Land and Property
Management Authority

Our reference: **09/08664**
Your reference: **05_0198**

**Re: Environmental Assessment Exhibition – Major Project Application 05 0198
Proposed Residential Subdivision of Lot 1 DP134787, Lot 1 DP167380, Lot 2
DP961928, and Part Lot 4 DP1054848 (sic, now Lot 5 DP1117326) at Walmsleys
Road and Stott Street, Bilambil Heights**

NOTE
PHOTOGRAPH SCALE NOT CONTROLLED, HENCE APPROXIMATE. DISTORTIONS AT
WESTERN DEVELOPMENT PERIMETER DUE TO TOPOGRAPHY IN 15-20m RANGE

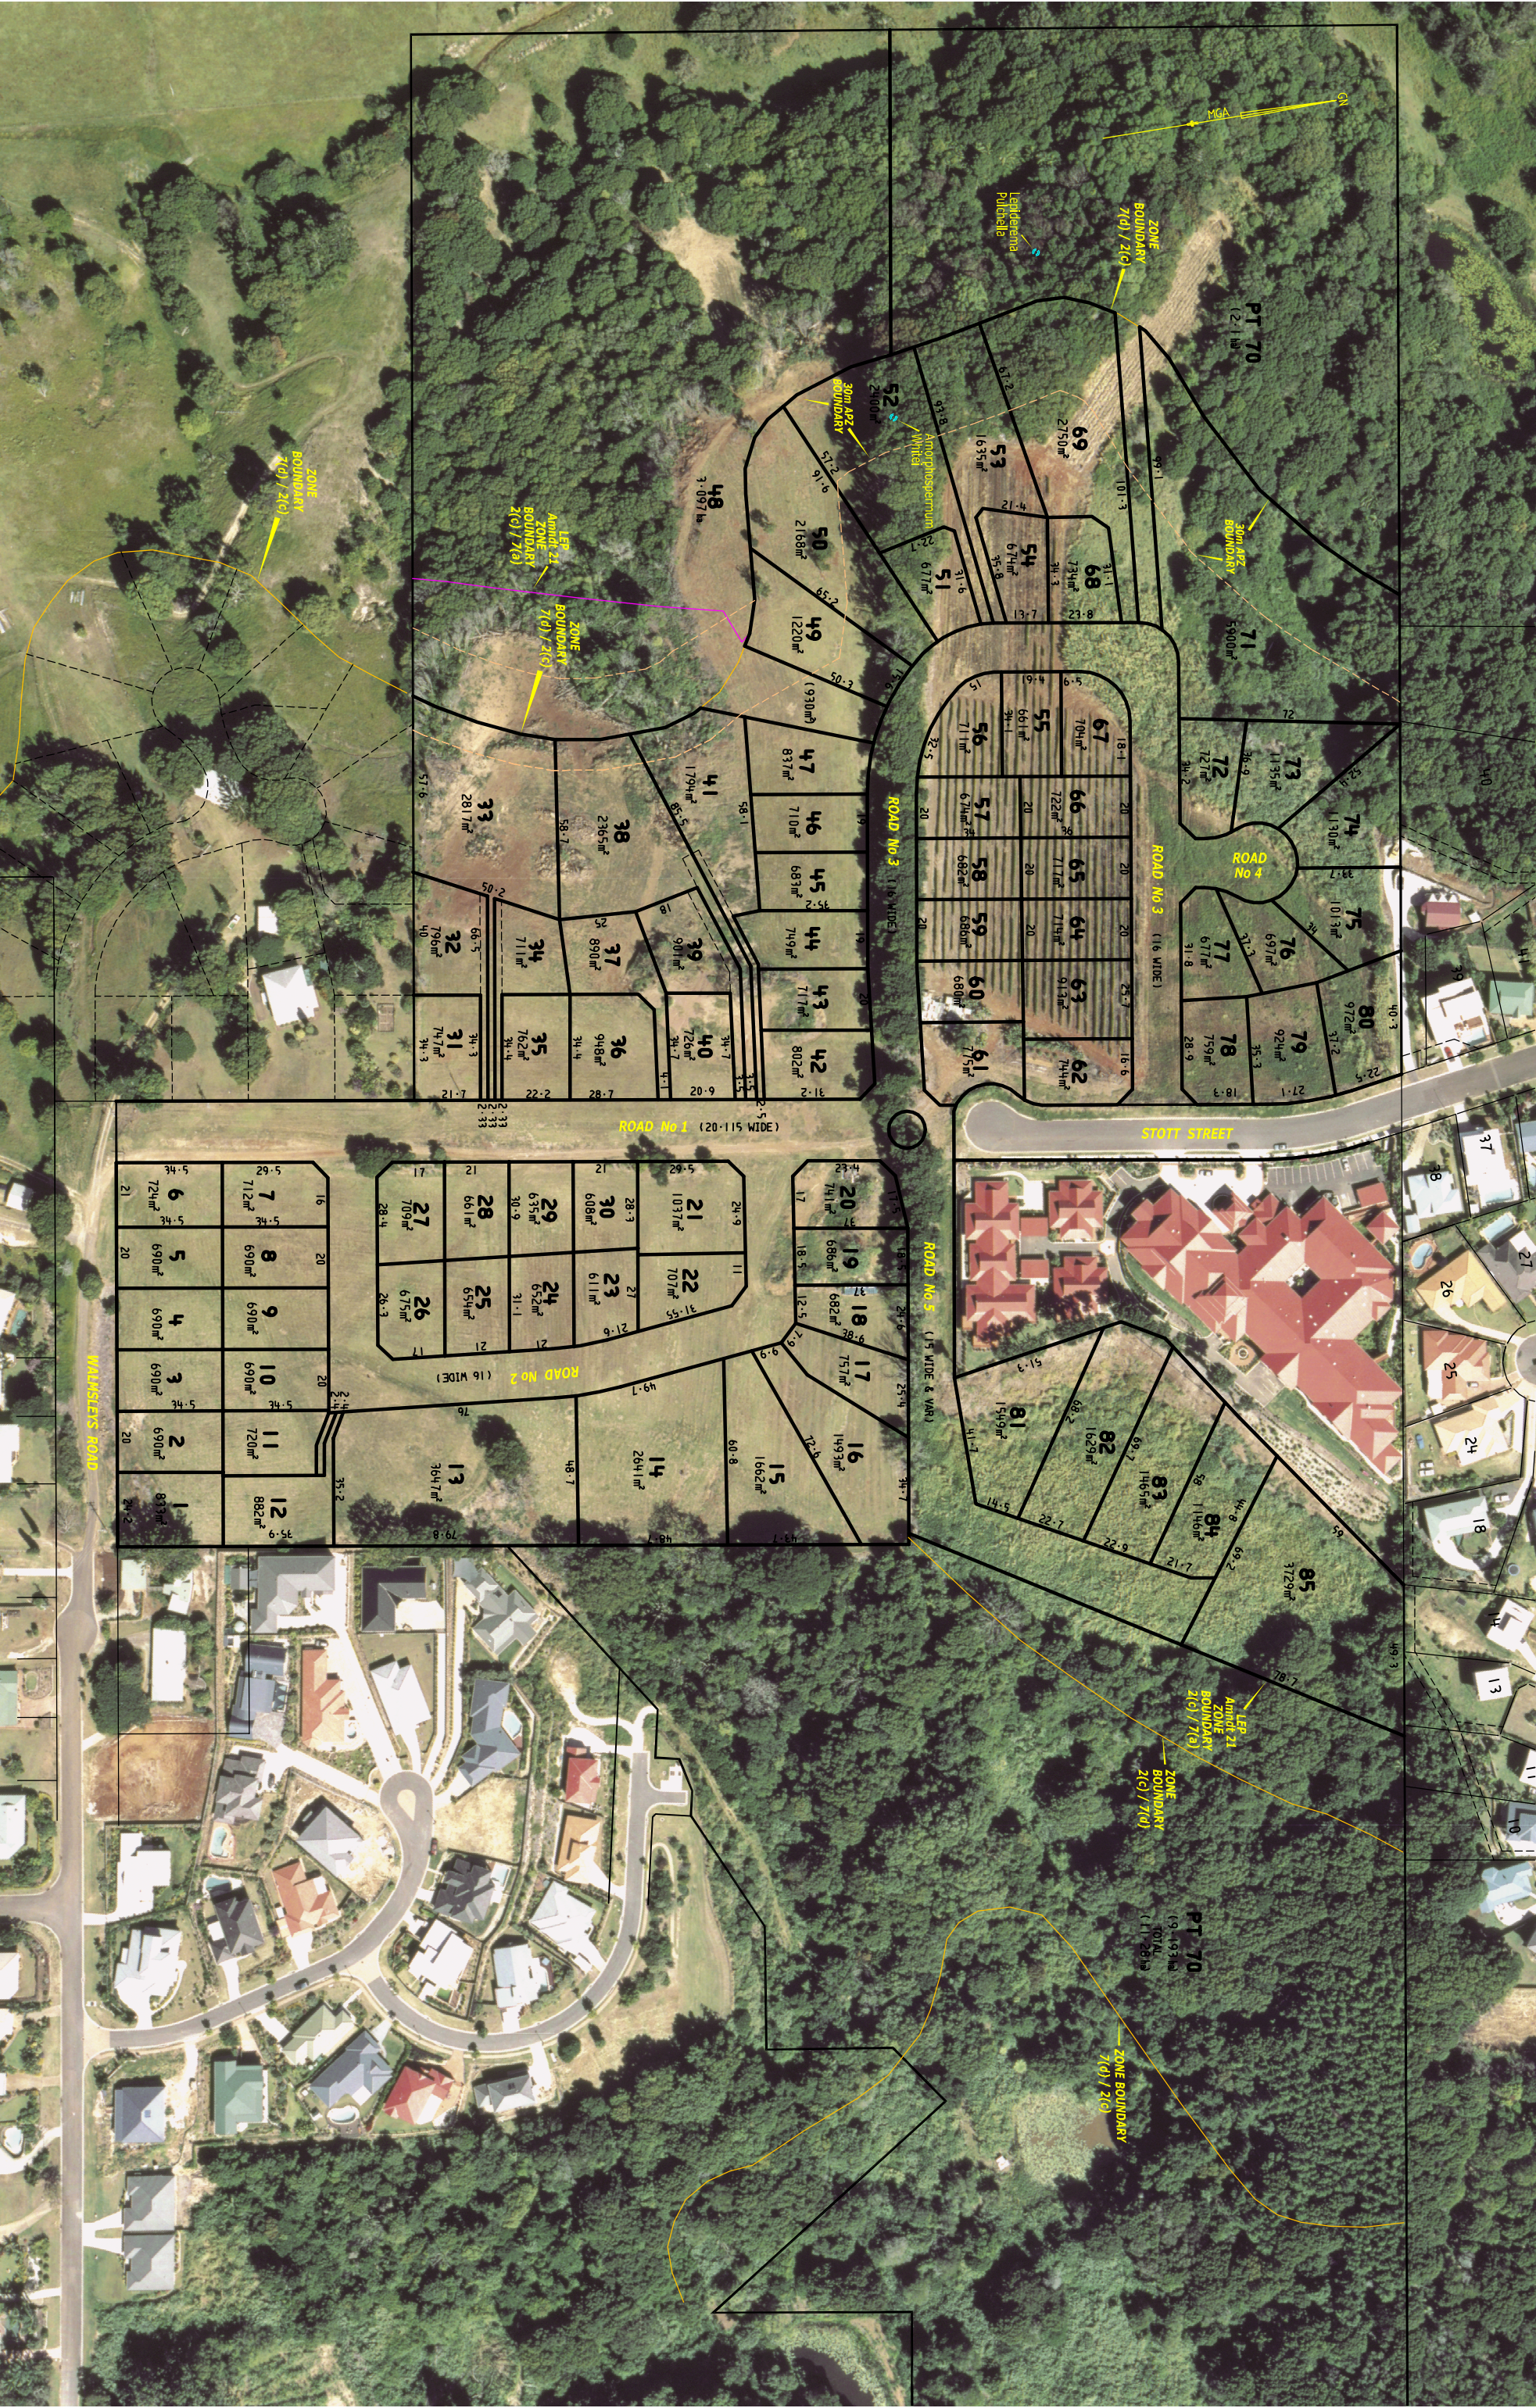
- The LPMA notes the disclaimer attached to the '**Proposed Subdivision Plan Overlay on Aerial Photograph**' (Annexure 9): "*PHOTOGRAPH SCALE NOT CONTROLLED, HENCE APPROXIMATE DISTORTIONS AT WESTERN DEVELOPMENT PERIMETER DUE TO TOPOGRAPHY IN 15-20M RANGE*". Care is required when using uncontrolled aerial imagery to reference proposed on-ground activities, such as weed control (comparisons between the attached Figure 1 and Annexure 9 in relation to the location of the western boundaries of the Subject Site are invited). Inadvertent encroachments onto neighbouring lands can occur where the locations of property boundaries aligned with particular features on an image differ from the actual property boundaries as referenced to on-ground features. The use of global positioning systems, or Ground-truthing or surveying prior to the commencement of works, is recommended.
